Location: Land South of Summer Lane & West of Pagham Road Pagham

Application No: RU.17/1295

Many thanks for giving RSPB the opportunity to comment on the proposed Brent Goose Mitigation Plan.

Please consult us again once the information requested above, has been provided.

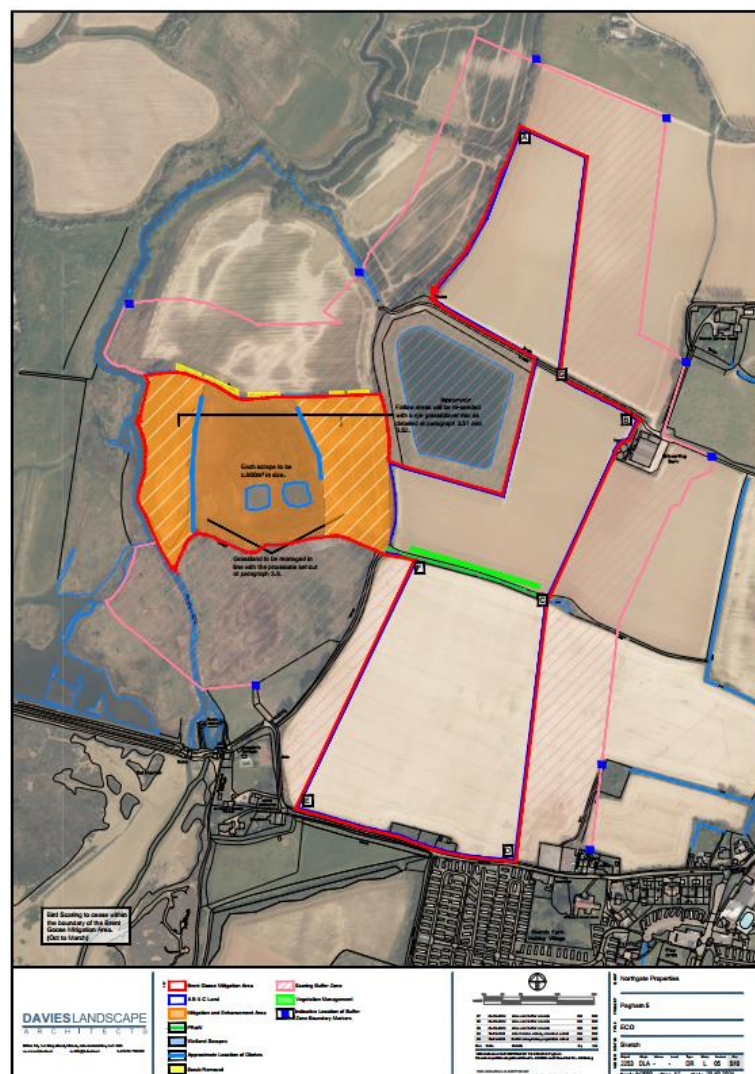
The 5ha plot (currently rough fallow) on field parcel SZ8798 9309 (refer to Plan ECO1) managed as permanent pasture would undoubtedly be attractive to foraging Brent Geese in winter, provided the grass was managed appropriately. The creation of the two 'scrapes' would also be of additional value for other wintering waterbirds and potentially for breeding wading birds.

However, we note the intention would be to manage this field parcel in effectively three plots, with suitable Brent goose foraging habitat provided in every year in the plot to the west of the 5ha permanent grass plot (by sowing winter cereals or a clover rich mix in fallow years), whilst the plot to the east of the permanent grassland will only benefit from no use of winter bird scaring initiatives.

This proposal whilst providing around 6ha of suitable Brent Goose foraging habitat, would not effectively replace the c.10ha lost and would appear unnecessarily complex to manage in perpetuity. We would suggest all of SZ8798 9309 (7.04ha) to be managed as permanent pasture. We would also recommend that the field is livestock fenced to allow any mowing regimes to be complemented by grazing with livestock. This 7.04 ha still falls short of the area of the foraging habitat lost to the development.
